The Sizewell C Project

**Natural England's Response to Examiner's Questions Part 2**

Planning Inspectorate Reference: EN010012

3<sup>rd</sup> September 2021

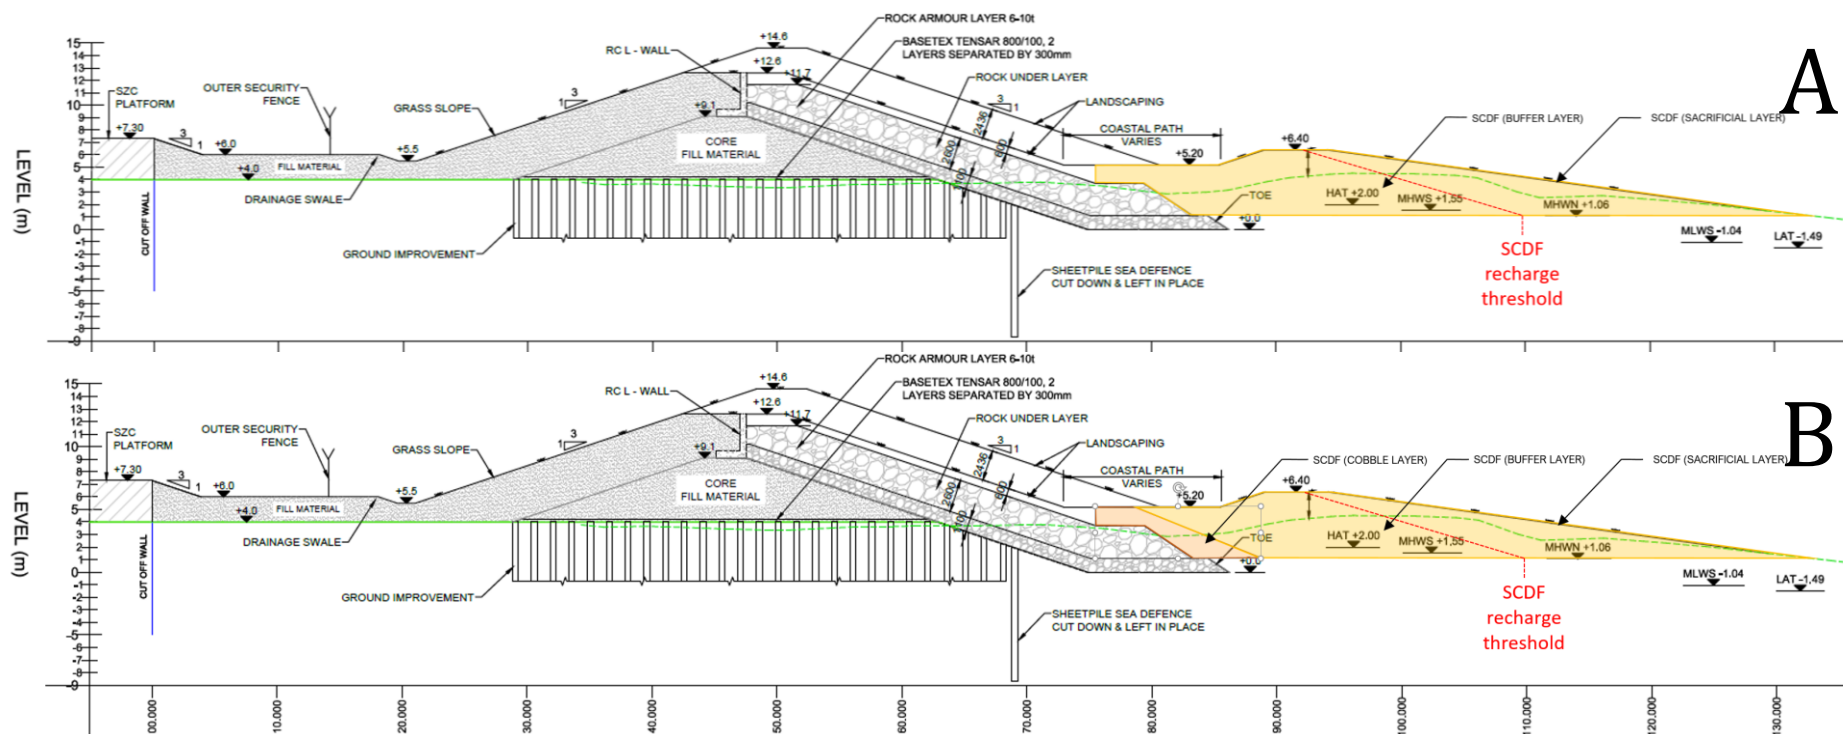
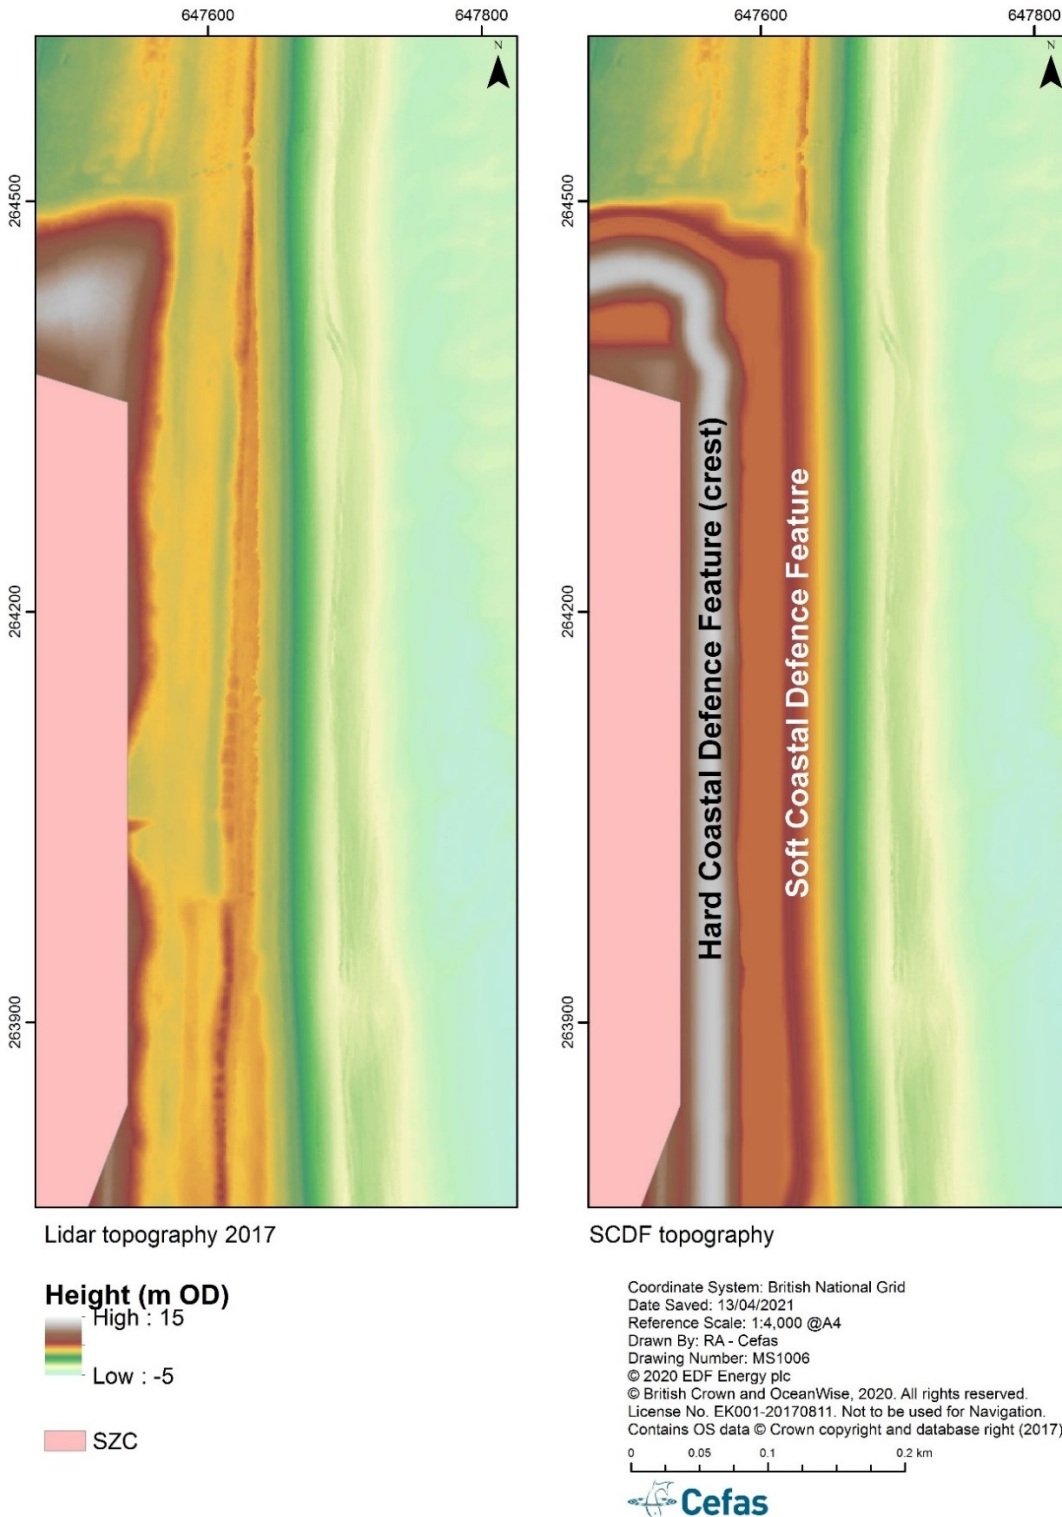
CG.2.9	The Applicant, NE	<p>Impacts on coastal processes</p> <p>NE's DL5 comments on the Preliminary Design and Maintenance Requirements for the Sizewell C Coastal Defence Feature [REP5-158], raises a number of issues:</p> <ul style="list-style-type: none"> <li>(i) In relation to the effect on Minsmere, what level of certainty can the Applicant provide that HCDF exposure would not occur and should the HCDF become exposed, are any further assessments in response to the NE concerns proposed to be carried out and, if so, what is the anticipated timetable for those assessments?</li> <li>(ii) In addition, NE seeks some of the work investigating triggers to deal with the uncertainty in the SCDF to be undertaken up front for the HRA to ascertain no LSE. Please can NE clarify the exact</li> </ul>	<p>Natural England advise that the further work required is already set out by the Applicant in TR544 Preliminary design and maintenance requirements for the Sizewell C Coastal Defence Feature [REP3-032].</p> <p>In it, the Applicant states:  'Further work required to refine the SCDF's coastal processes design and finalise the buffer and sacrificial layer volumes includes:</p> <ul style="list-style-type: none"> <li>• Setting the <math>V_{recharge}</math> (the threshold volume for SCDF recharge) for the CPMMP.</li> <li>• Extending the modelling period from the end of the operational phase (2099) to the end of decommissioning for SLR cases.</li> <li>• Modelling a range of particle sizes between 10 and 80 mm to optimise SCDF particle-size selection and SCDF performance.</li> <li>• Consideration of whether gravel model calibration work should be undertaken to reduce model uncertainty, specifically measurements of the</li> </ul>

nature of the work that is required to be carried out up front?	<p>groundwater properties (hydraulic conductivity) for Sizewell's supra-tidal sediments, which are the closest analogy to the SCDF available. Full-scale physical modelling may also be required to finalise the design prior to SCDF construction.'</p> <p>Natural England advise that this work is undertaken up front in order for us to agree with the Applicant's no AEol conclusion.</p>
DCO.2.0	The Applicant, ESC, SCC, Natural England, MMO	Attention is drawn to the Commentary on the DCO which includes commentary on the Deed of Obligation	Natural England request further information on what the Examining Authority wish us to respond to here.
FR.2.18	The Applicant, Environment Agency, Natural England	<p>Flooding – Landowner Consents</p> <p>In response to ExQ1 FR.1.14 the EA [REP2-136] raised a concern over flood risk to land. They requested that the landowners should be consulted, and their legal easements sought for increase flood depths. Please provide an update on the progress with respect to EA guidance on thresholds and what action has been taken negotiating with relevant landowners and Natural England.</p>	To the best of our knowledge our Sizewell casework team has not been involved in these negotiations. We defer this question to the EA who may be in a better position to give an update.
